Planning Consultation Memo

Date	Planning Officer	Environmental Health Officer
21/10/2022	Mrs Sarah Madyausiku	Terry Vincent
Planning Application Number	Worksheet Number	
6/2022/2218/COND	WK134267

Address: 35-37 Howardsgate Welwyn Garden City AL8 6AP

Application Details: Submission of details pursuant of condition 1 (noise), 2 (noise control) and 3 (ventilation) on planning permission 6/2022/0733/FULL

ROOF LAYOUT

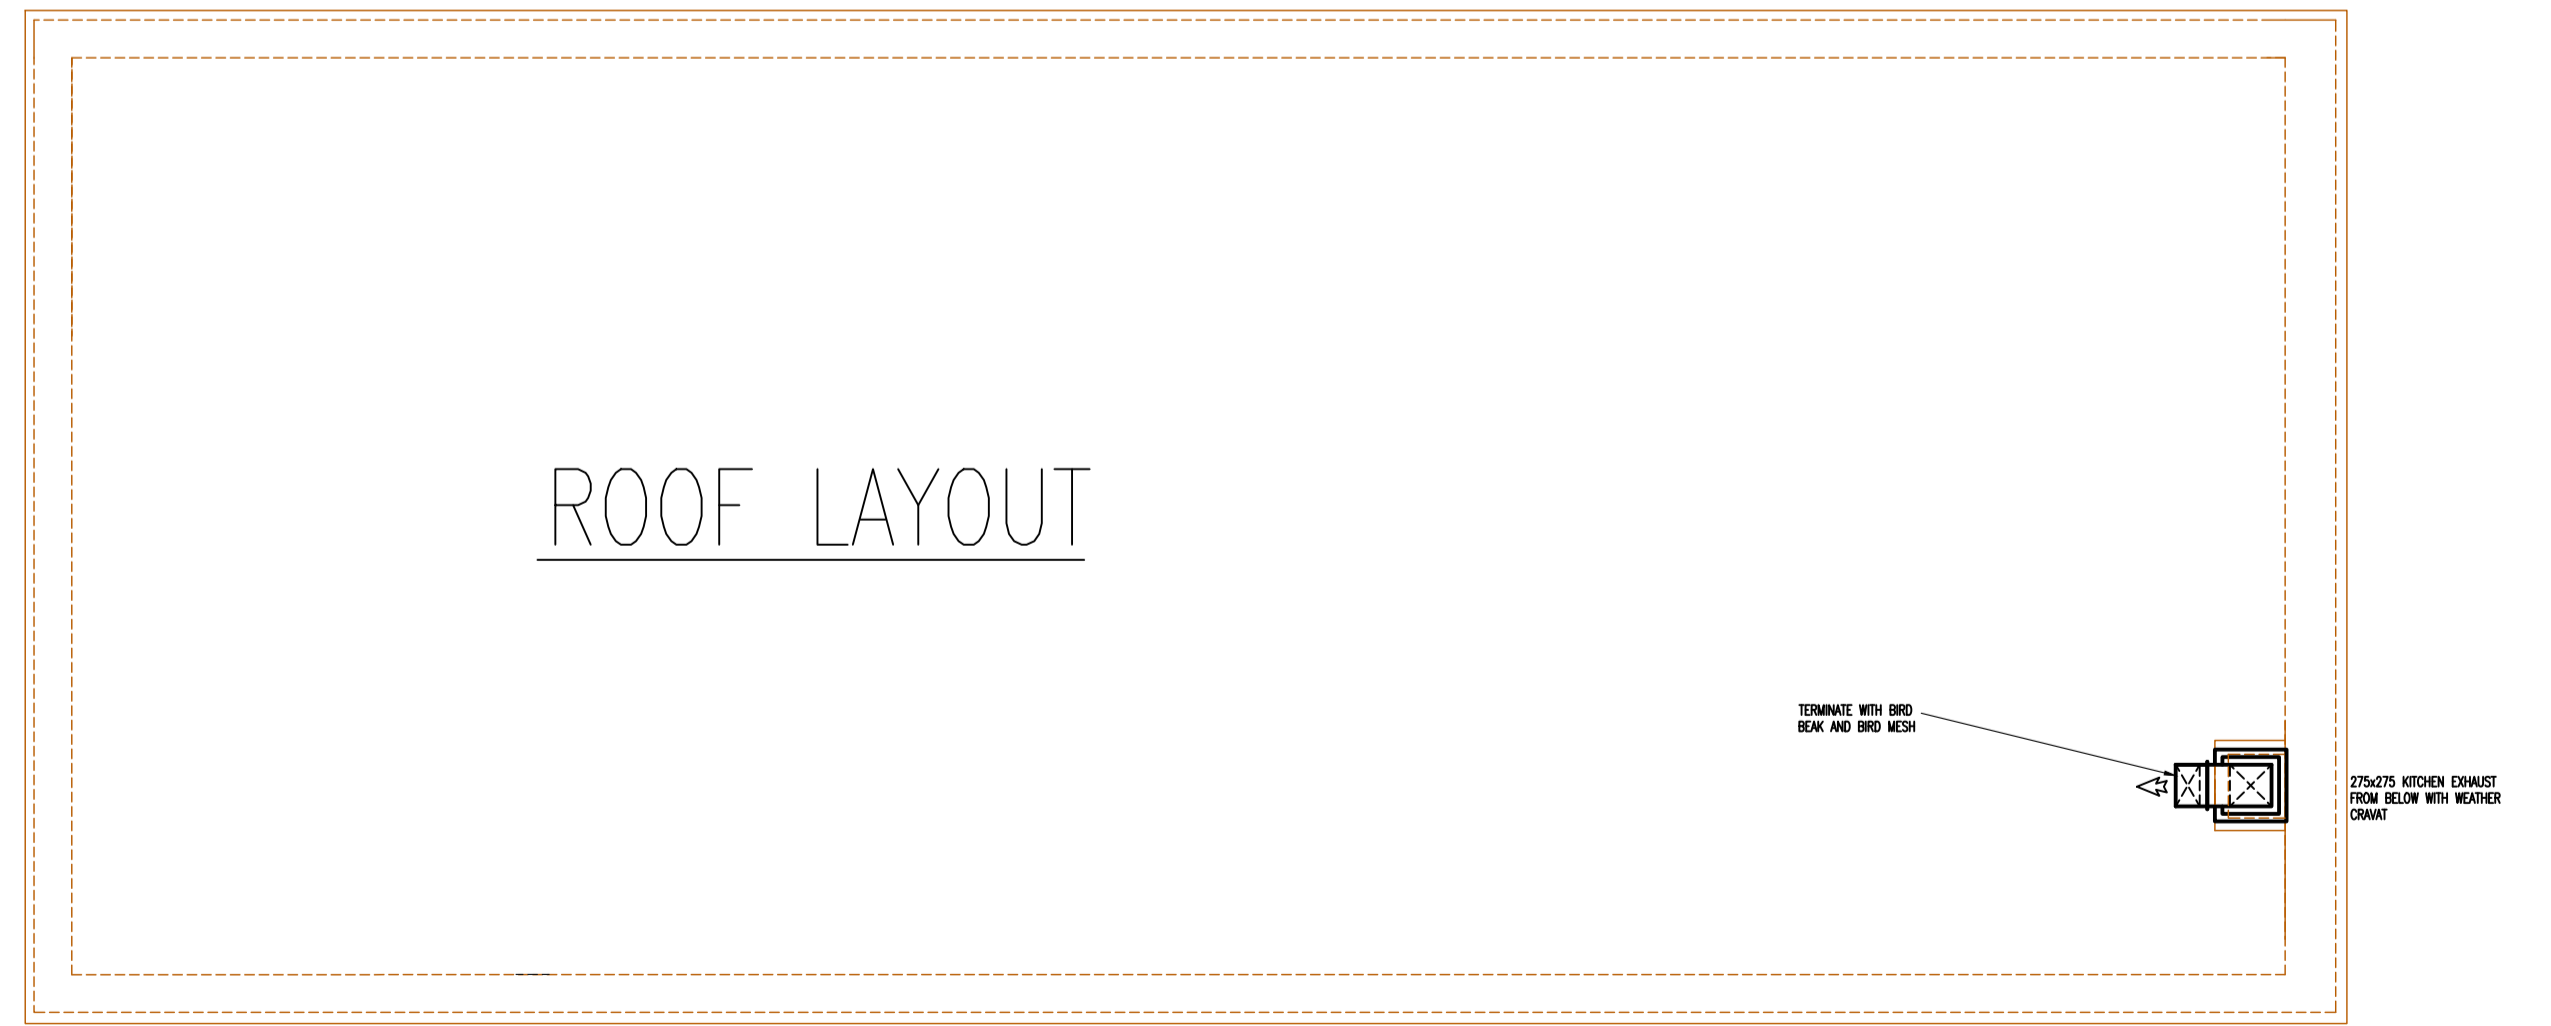
“1.5 Compliance with Planning Condition 1 is predicted to be achieved subject to the installation of a 2m high impermeable acoustic barrier (minimum surface density of 10kg/m²) to the east of the three AC condenser units at roof level.”

No evidence has been submitted to demonstrate that the acoustic barrier has been installed. The condition can only be discharged once evidence has been submitted showing that the barrier has been installed. In addition to this, evidence must be provided that the barrier is installed within the correct place and has the correct surface density as stated within the noise report.
